Please upload as sub-plan and correspondence

I have noted that the above application has received a representation stating "The location plan is out of date, surrounding property is missing . The rear wall on the block plan is not at right angles to the sides and is not continuous, there is a small recess/projection to the rear elevation."

LOCATION PLAN - 1/1250

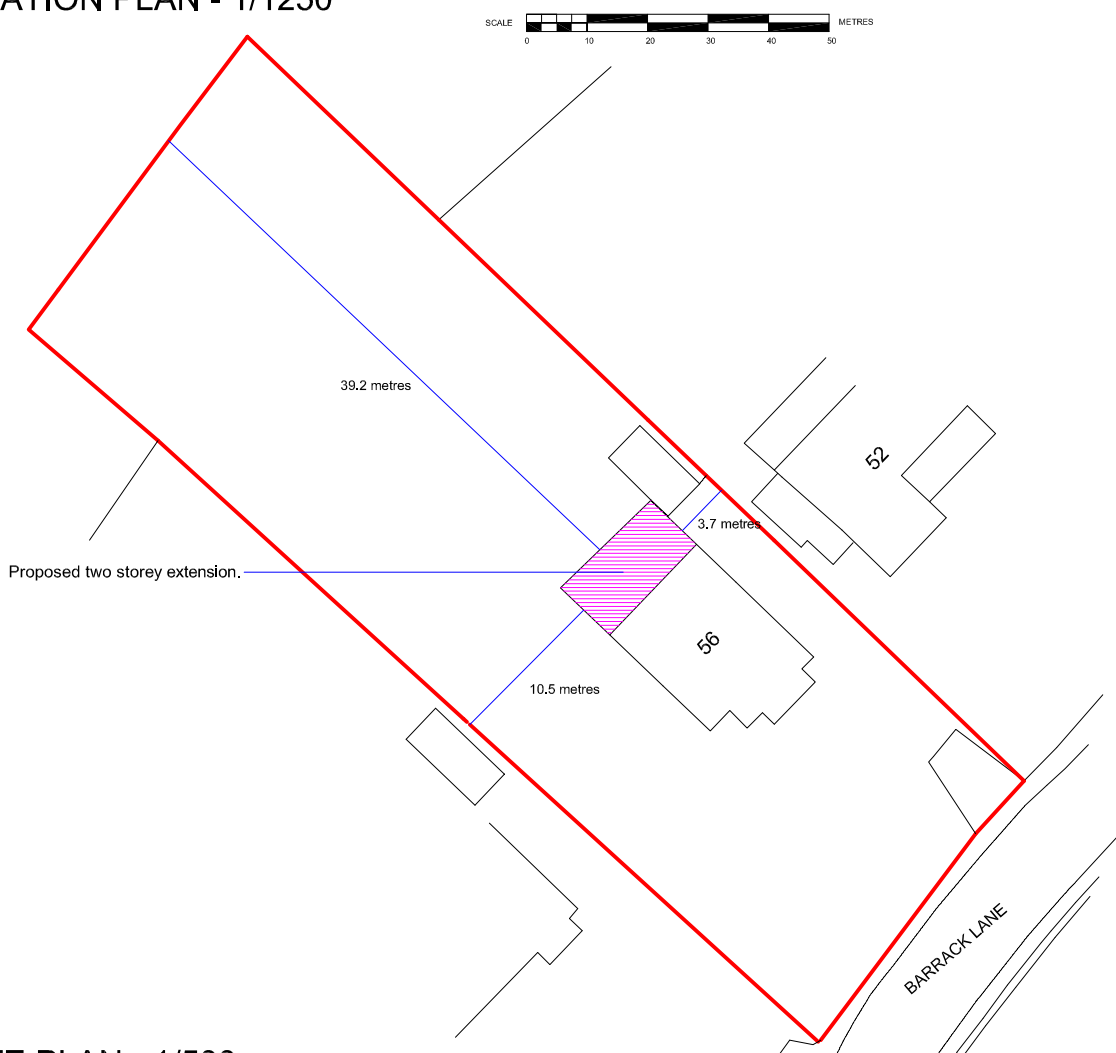
It's also noted that the application site falls within a TPO (Bognor No. 2). Please can you confirm if there is any impact on the tree roots if the proposal takes place?

I missed the conservatory off the location plan – now added, please see attached.

As can be seen from the site plan, the new development not far off, replaces the existing conservatory extension and is sited outside the influence of the trees as shown.
